Date: 15 December, 2015

Re: Application: SSD 6624
described as "Sly's Quarry Expansion Project"
Applicant: Newman Quarrying Pty Ltd
Location: Jacky Bulbin Road, Tabbimoble Creek, NSW

**Figure 6 Predicted operational noise levels – Scenario 1 – Peak daily production with rock hammer**

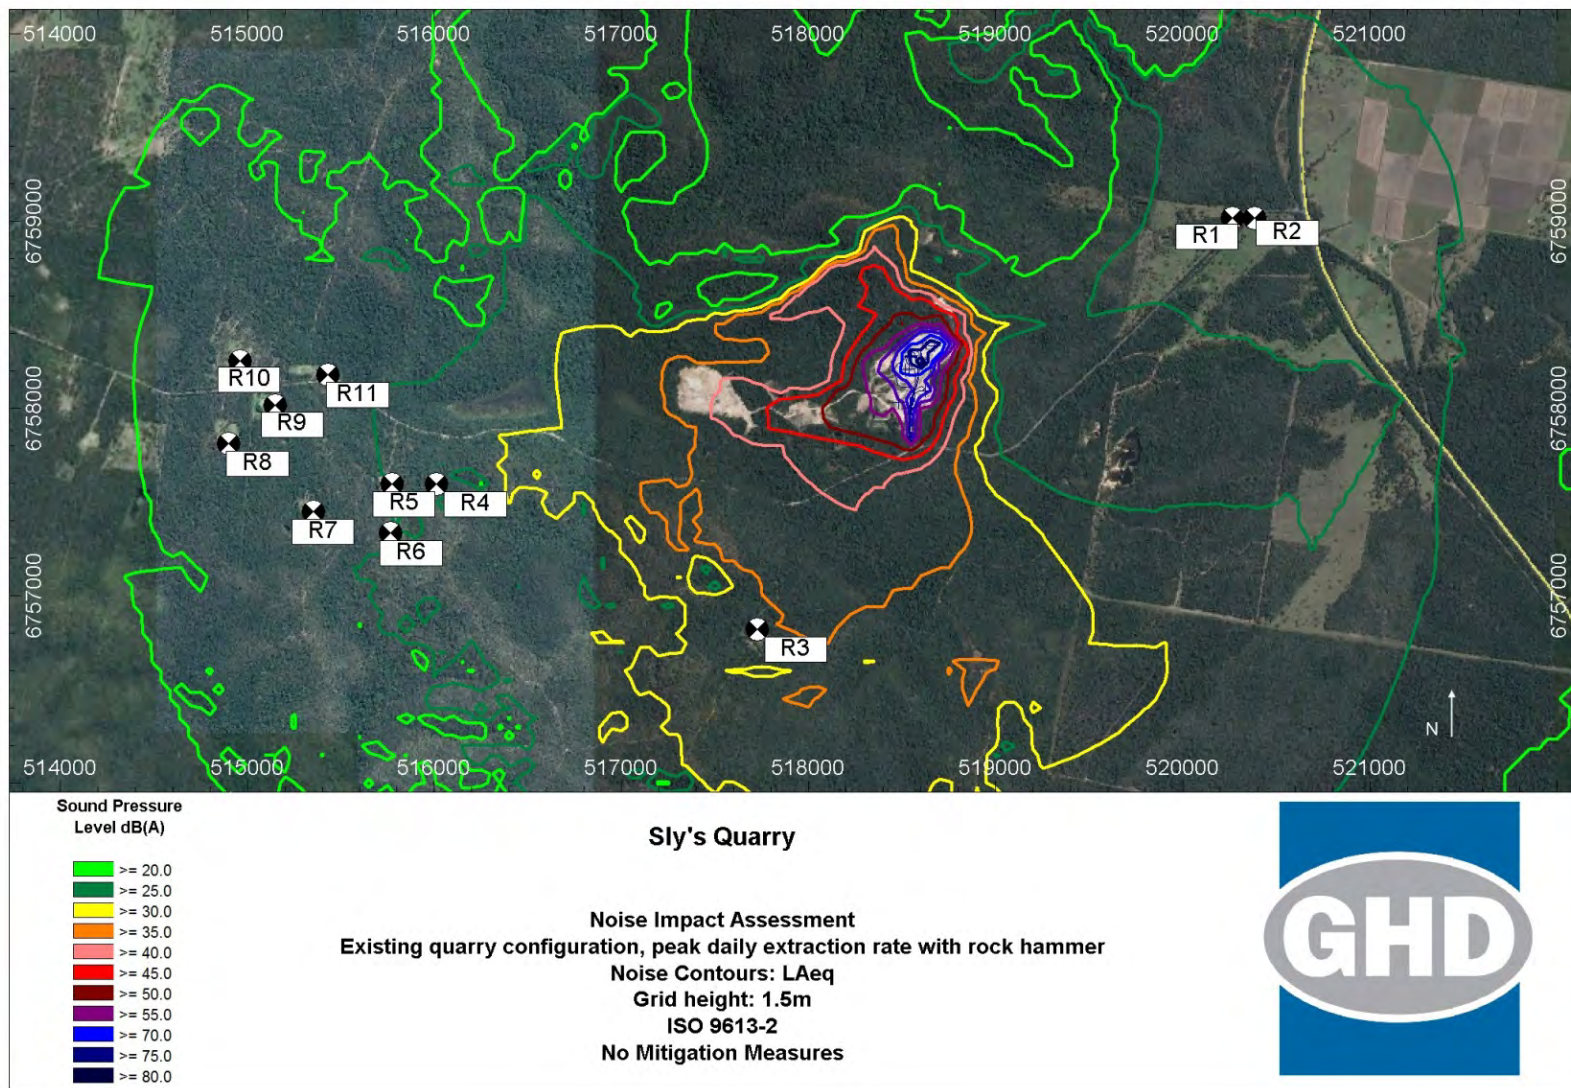
Mr Luffman directed my attention to his map on Figure 6 - Peak daily production with rock hammer which is found in the document 'Slys Quarry EP_EIS_Appendix D_Noise Assessment'. He explained that the lines appearing like isobars are generated by a computer analysis based on the noise levels collected at various locations indicated and also based on models of the type and level of noise to be expected by the operation. I hope that I am characterising what he said correctly. He said that what the analysis shows is that sound levels emitted from the quarry are expected to be below background at our house site. This assertion conflicts with our experience.

It also conflicts with our examination of that map which appears to show our house site inside the yellow line relating to the 30dB level, ie it shows our house site as over 30dB.
